**Fenwick Solar Farm
EN010152**

**Statement of Common Ground between Fenwick Solar Project
Limited and South Yorkshire Fire and Rescue Service**

Document Reference: EN010152/APP/8.11

~~April~~ July 2025
Revision Number: ~~000~~01

Plate 1: BESS Area Proposed Design

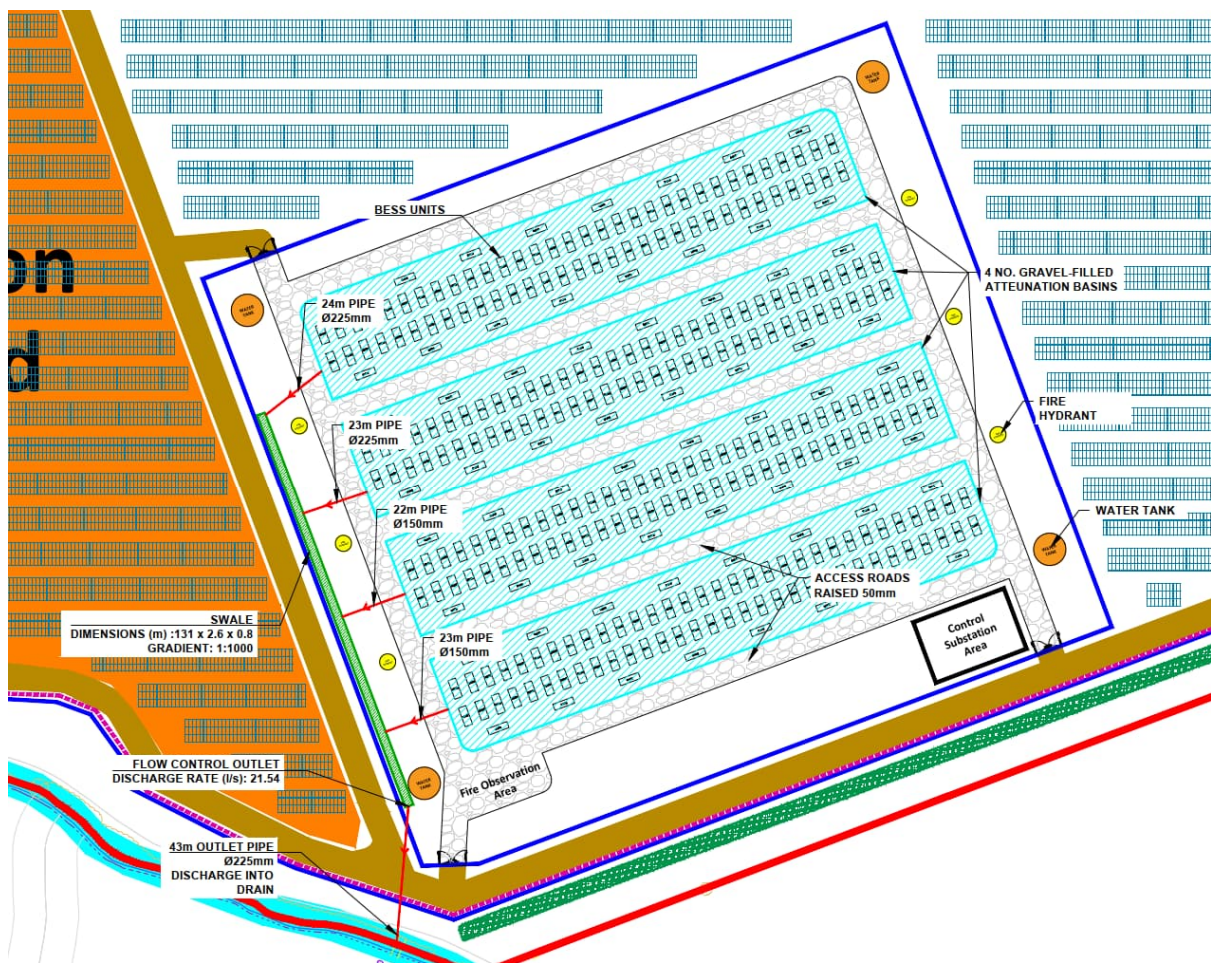
4	Framework BSMP Volume III, Appendix 9-4: Framework Drainage Strategy	Consideration regarding the environmental impact of a potential BESS fire.	SYFRS expressed concern that BESS fires can significantly harm the local environment and recommend developing a plan to guide discussions regarding the suitability of the location of the BESS Area. This should identify all sensitive receptors within a 1 km radius of the BESS Area for appropriate emergency planning.	<p>The Applicant confirms they are engaging with the Environment Agency regarding the environmental impact and mitigation measures relating to the BESS Area.</p> <p>As outlined in the Framework BSMP [APP-205], a site-specific plume analysis study will be conducted once the specific battery technology to be used for the Scheme is confirmed. This will be in accordance with the latest NFCC guidelines and assess the potential environmental impacts of a BESS fire on sensitive receptors within 1 km. It will consider toxic gas emissions and particulate matter in the context of Public Health England (PHE) guidelines.</p> <p>It should be noted that Volume III, Appendix 9-4: Framework Drainage Strategy [APP-160] also includes details regarding the management of firewater to prevent impacts to sensitive receptors from contamination.</p> <p>The Applicant understands that SYFRS is in agreement on this matter.</p>	Agreed
